Final Acceptance Punchlist

El Paso County – Department of Public Works – Stormwater Section

Project Name:	Widefield Park & Rec Improvements
EDARP File Number(s):	PPR2213, CON2261, ASB2316
ESQCP Number:	ESQ2250
Attendees:	DPW SW: Ben Jones DPW Development Services: N/A Developer: David Gish, Nuun Construction, Todd Kimes (LKA Architects), Jim Houk
Date of Walk-through:	04/08/2026
Walk-through Number:	1st

C7.5

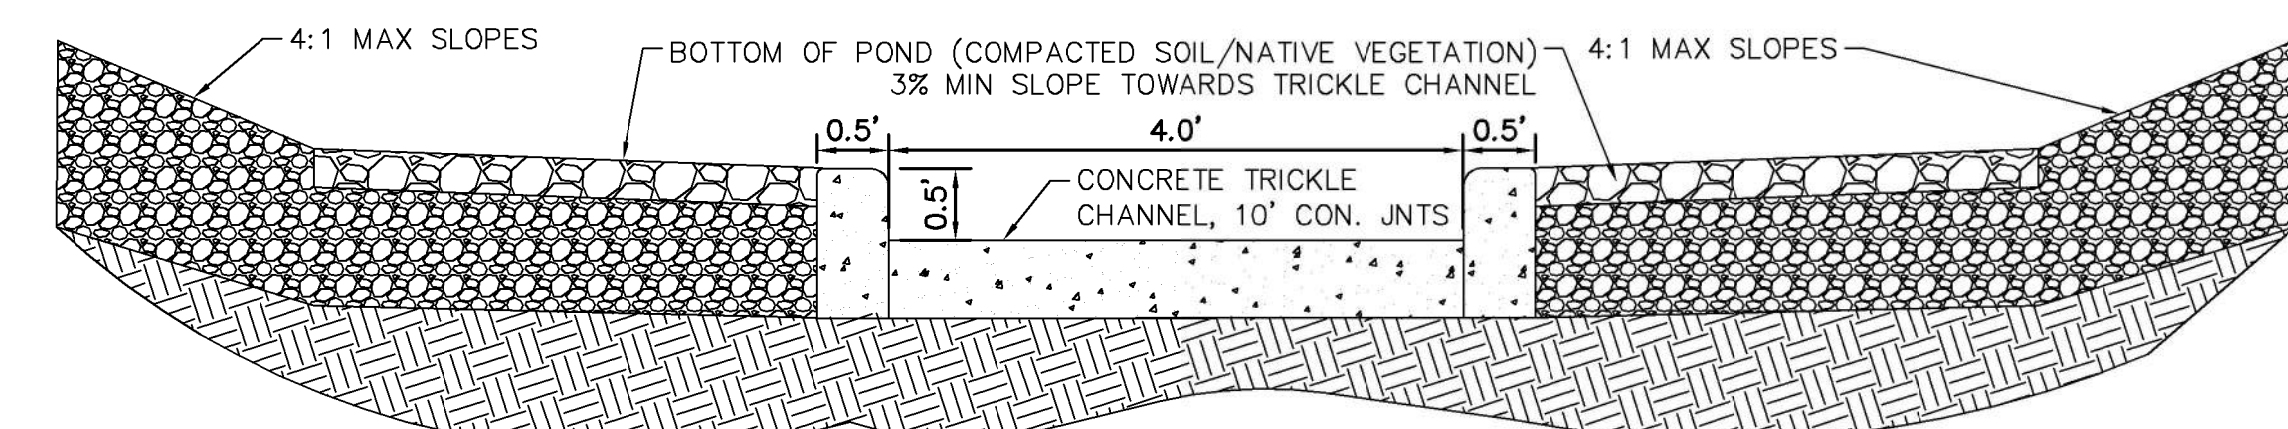
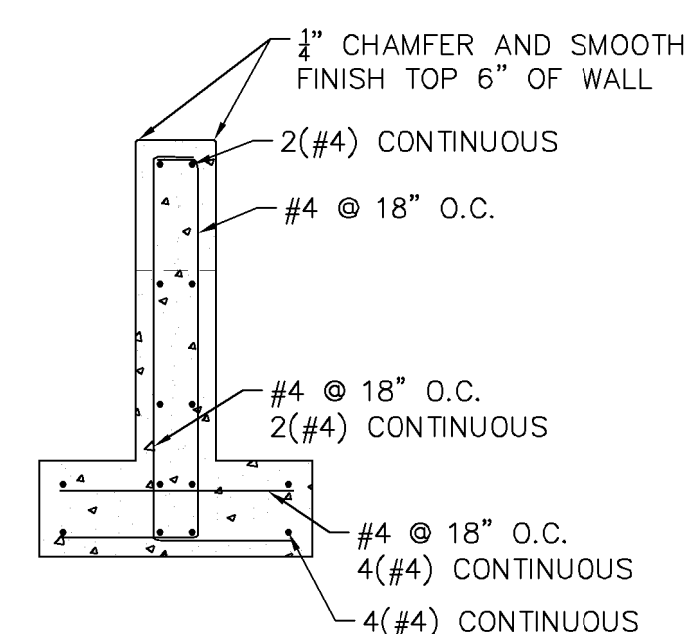
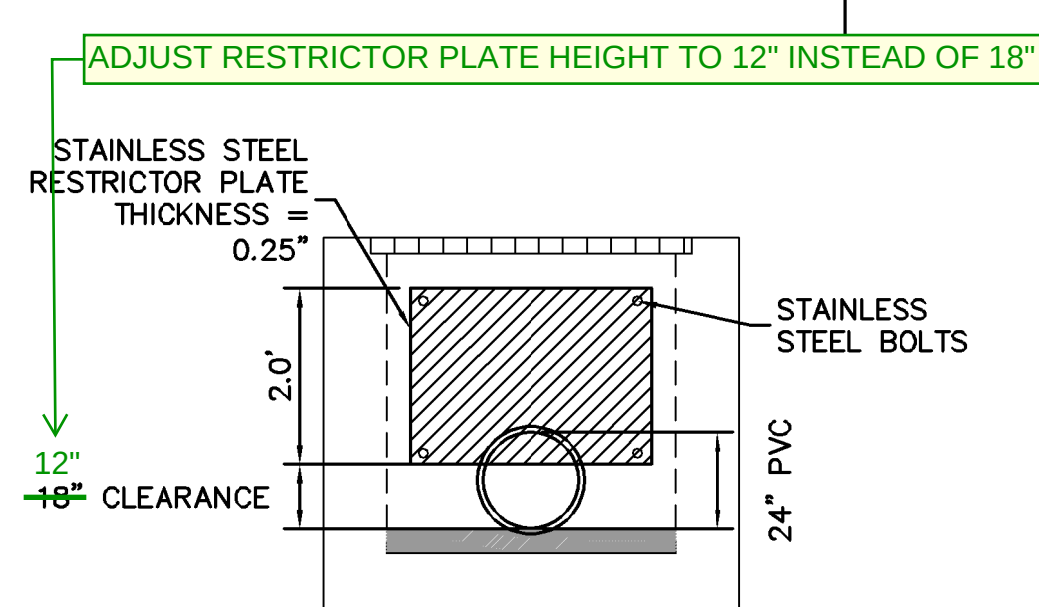
- Outlet Structure
 - Clean Trash Rack and repair lock mechanism. See photo 4.
 - Clean debris from Microscreen. Microscreen is a different material than called out on plans. Plans call for Johnson Vee Wire No. 93. Send updated detail on current screen material or replace per plans. See photo 5.
 - Add concrete crossmember to top of outlet structure where missing between microscreen and orifice plate. See photo 6.
 - Orifice Plate Gasket is inadequate and needs to be replaced. Consult Engineer of Record.
 - Microscreen material was welded to orifice plate. Remove material from orifice of consult Engineer of Record.
 - Restrictor plate measures 12 inches above outlet pipe invert. Plans call for six inches above outlet pipe invert.

- Trickle channel
 - Remove sediment. Dispose of sediment outside of pond. See photo 3.
- Forebay
 - Remove sediment. Dispose of sediment outside of pond. See photo 1.
 - Repair erosion on each side and stabilize. Consult Engineer of Record regarding installation of riprap at these two locations. See photo 2.
 - Clean out Drainage Ditch before pond Forebay. See photo 10.
- Emergency Spillway
 - Elevation of Emergency Spillway, show on as built.
- Area drains
 - 2 Inlet drains. South side above pond, show on as built.

KHA Response: McNichols perforated metal screen is an acceptable substitution.

KHA Response: Steel cross member solution proposed by the contractor is acceptable and outlet structure will function as hydraulically intended.

KHA Response: Restrictor Plate specified to restrict 6" from the top of pipe, not 6" clear, and was installed correctly. Refer to the Letter from the EOR confirming this condition.

KHA Response: Stabilization of erosion via rip rap is recommended.
